Application No.	2023/91547
Proposed Development:	Erection of barn
Location:	Woodend Farm, Greenside Road, Thurstonland, Huddersfield, HD4 6XA
OS Map Reference	SE 417659.581 411802.4154
Applicant/Agent:	Wood Associates-Architecture+Interiors
Class:	Minor Developments

**Consultation Response from KC,
Policy****2023/91547 Woodend Farm, Greenside Road, Thurstonland, Huddersfield, HD4 6XA****Erection of barn****Responding Officer: Jacob Parker-Henry**

STORAGE BARN
PLAN & ELEVATIONS

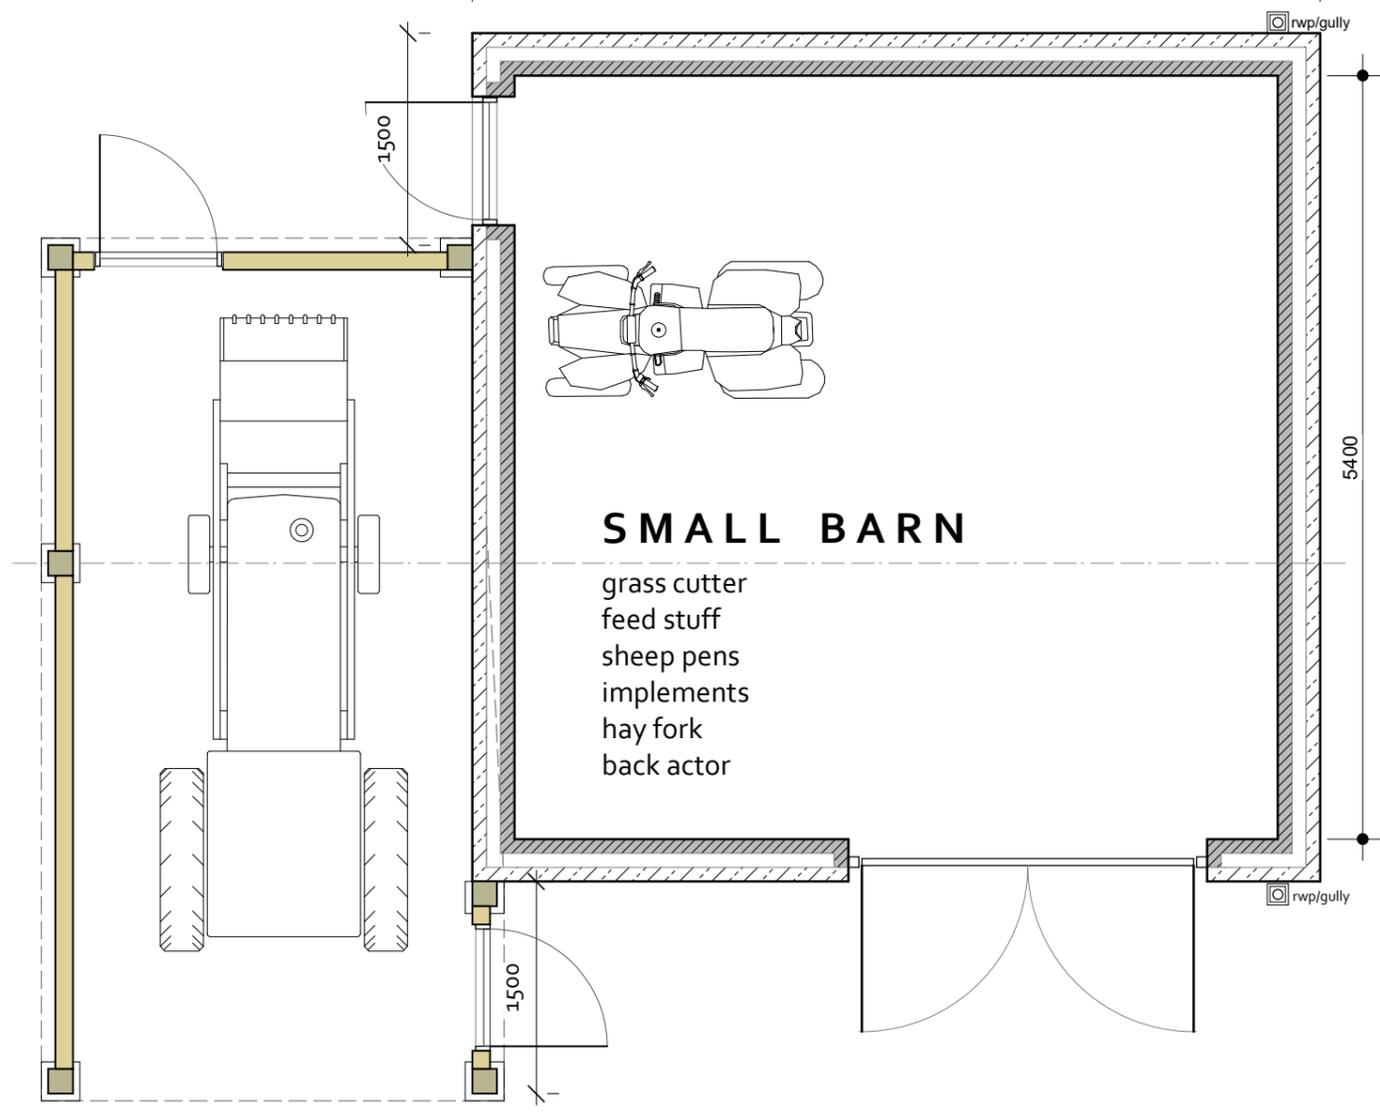
The site of the application is a field to the south of Wood Lane and is 0.45ha in size. The field appears to be unused. The proposed barn is located to the south of the field, and the floorplans show space for an agricultural type vehicle, with a connected storage room. The floorplans state that the proposed barn would be used for sheep pens, as well as storing implements and machinery. However, there is no indication of how the space may be divided, nor of whether any sheep are kept. The plans also do not give information regarding access.
